Re: Juan Tabo Hills Request for CLOMR Response to Comments (Project # 1005278)

Below, please see our response to your comments dated April 8, 2015 for our request for CLOMR for Juan Tabo Hills Estates.

TITLE: JUAN TABO HILLS UNIT 3B
TIJERAS ARROYO IMPROVEMENTS
BANK PROTECTION

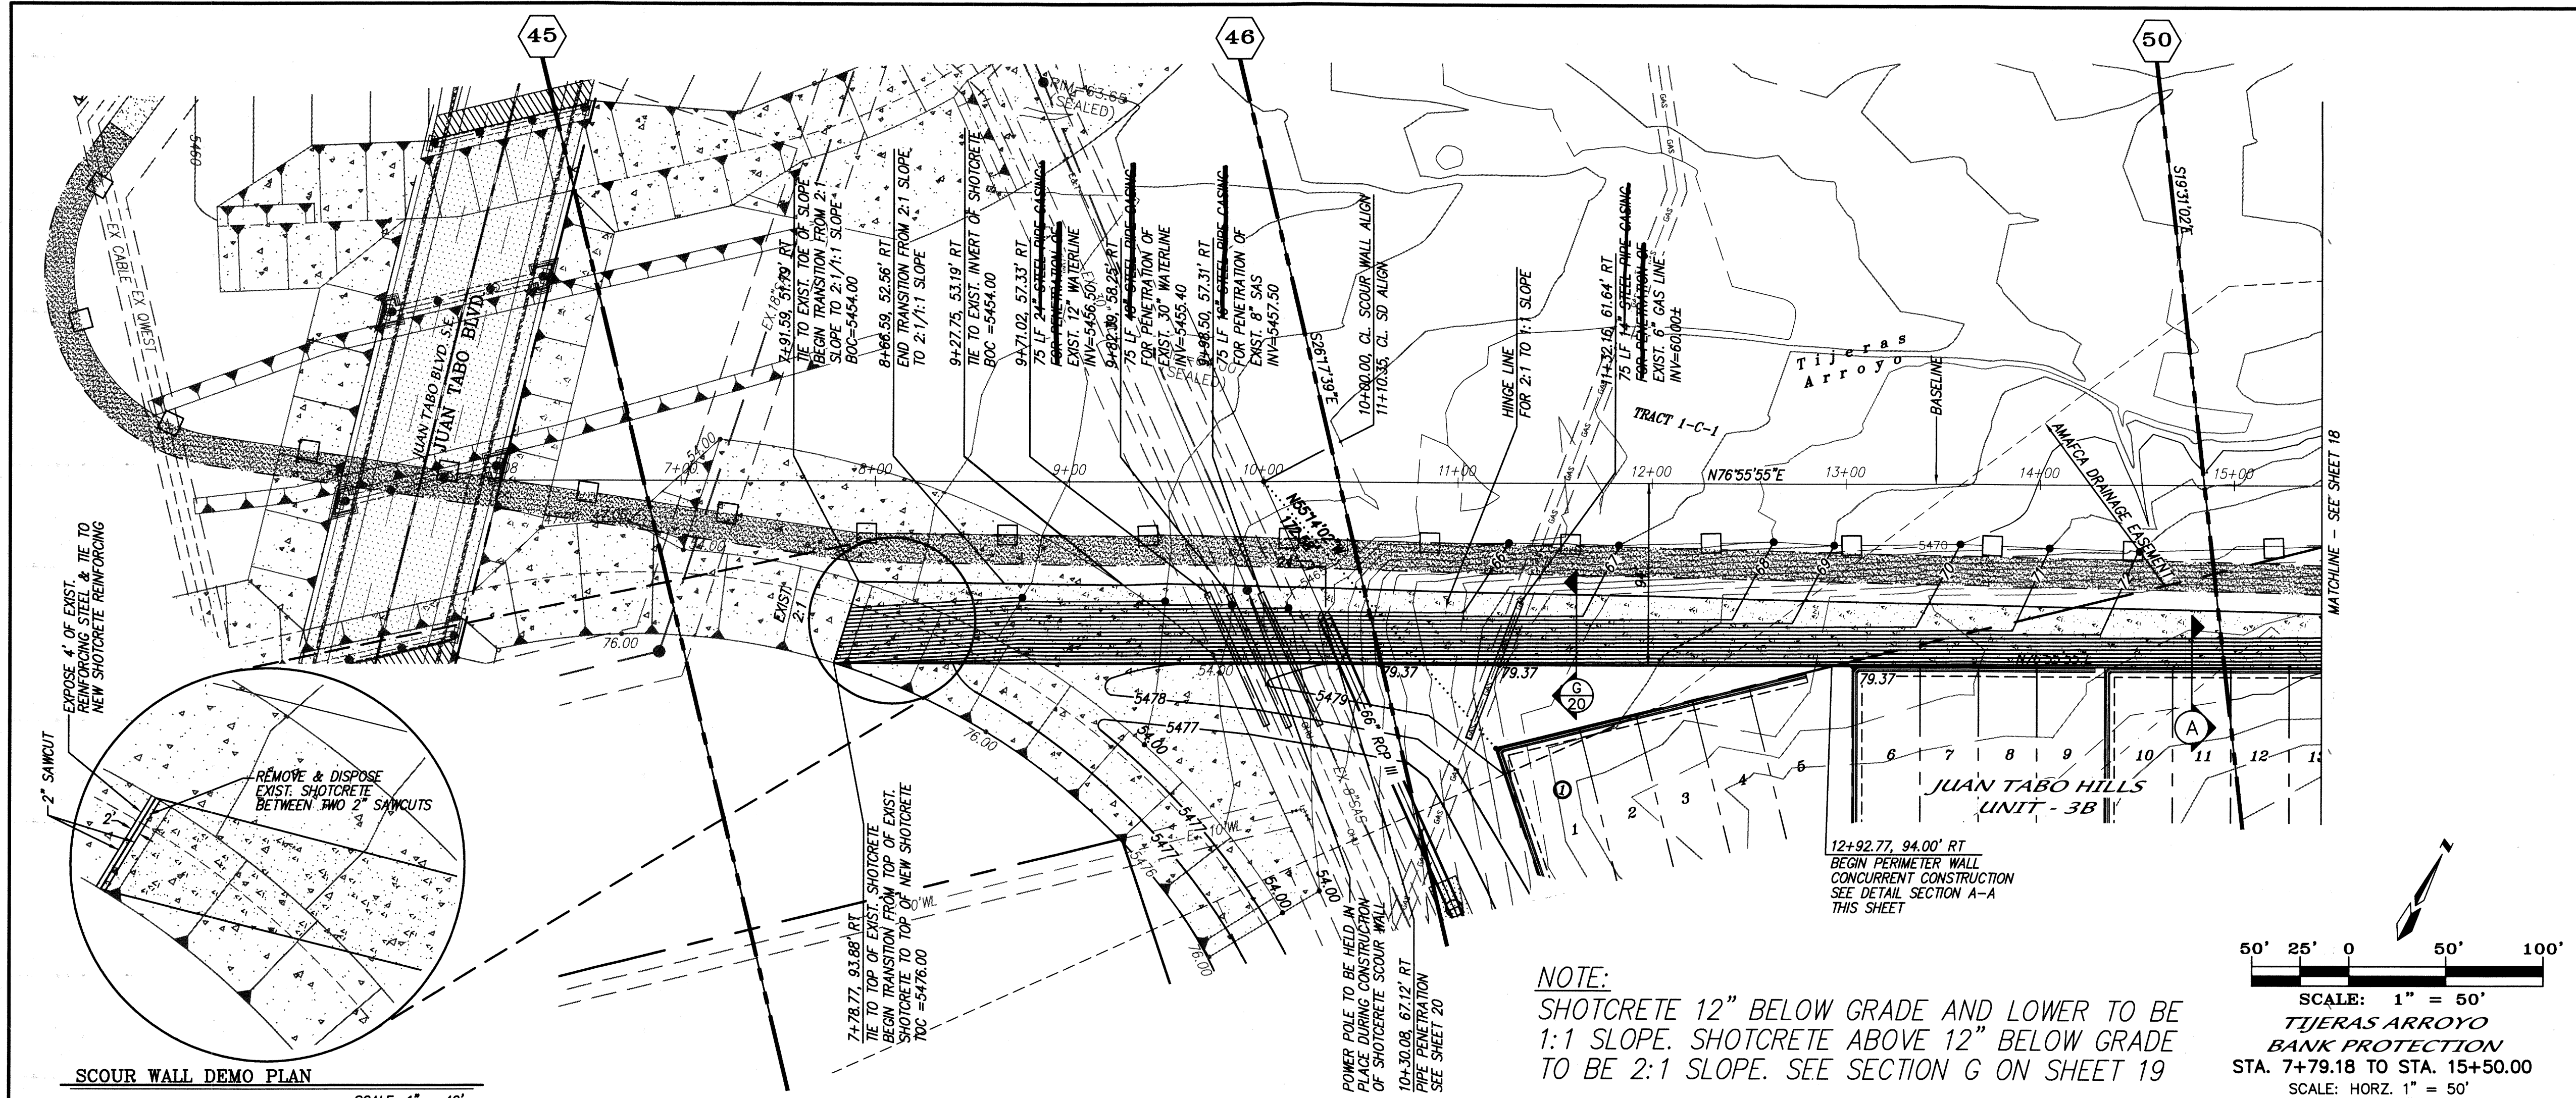
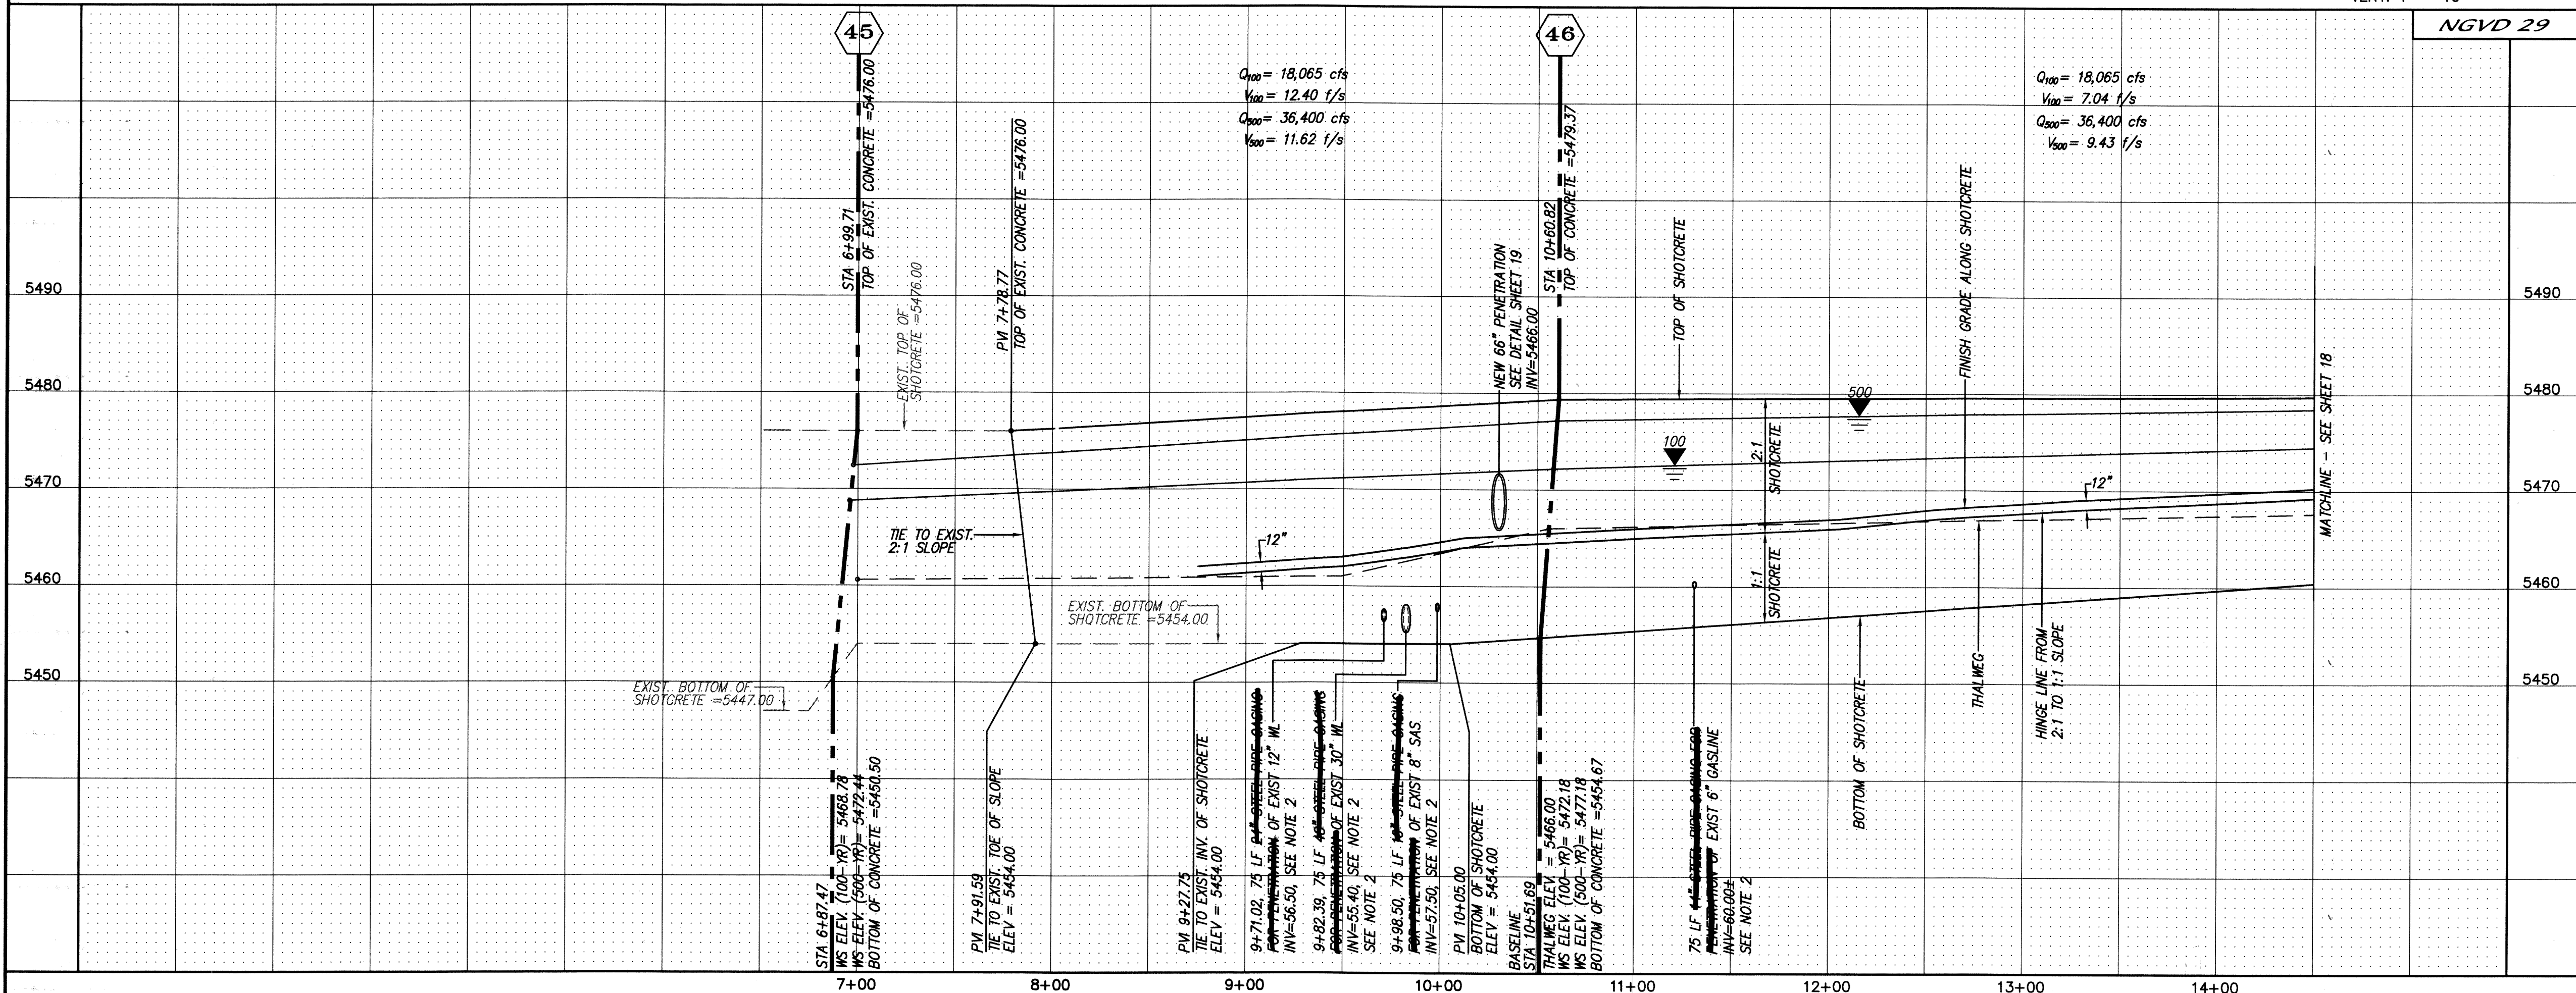
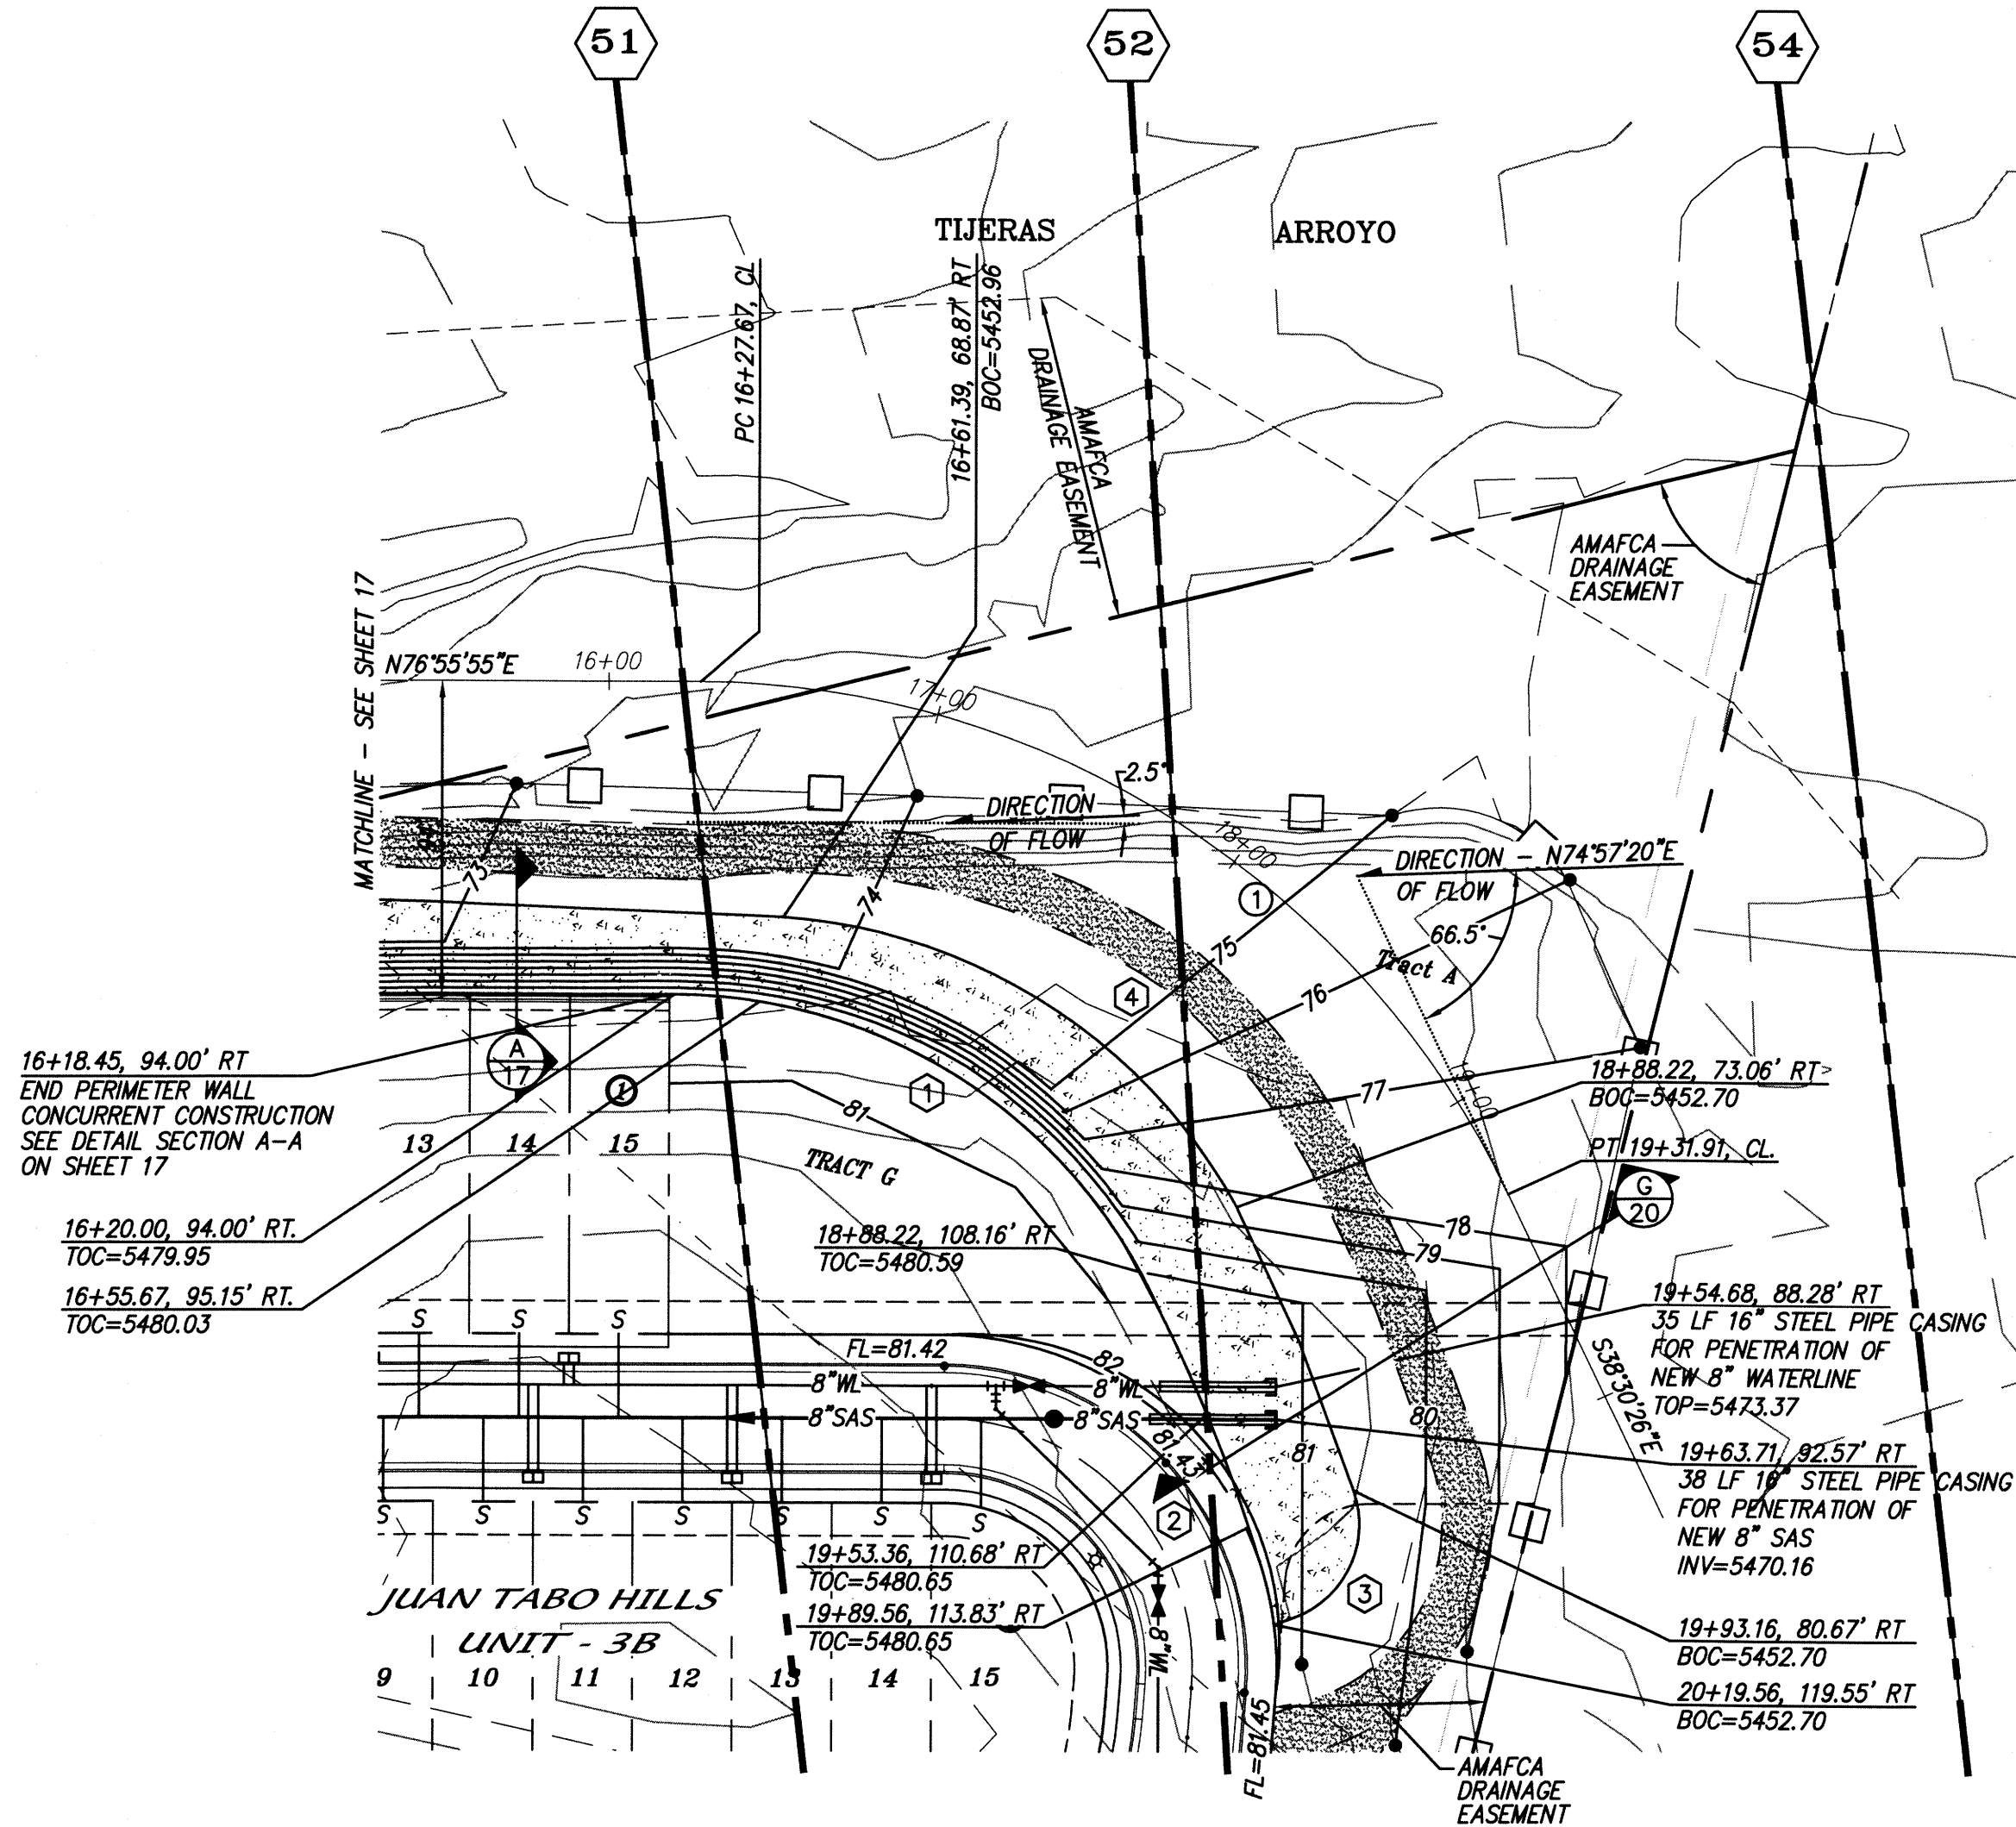
10. Provide a plan showing river station stationing. **The stationing is shown on the Bank Protection Plan and Profile. That stationing match the HEC-RAS model.**
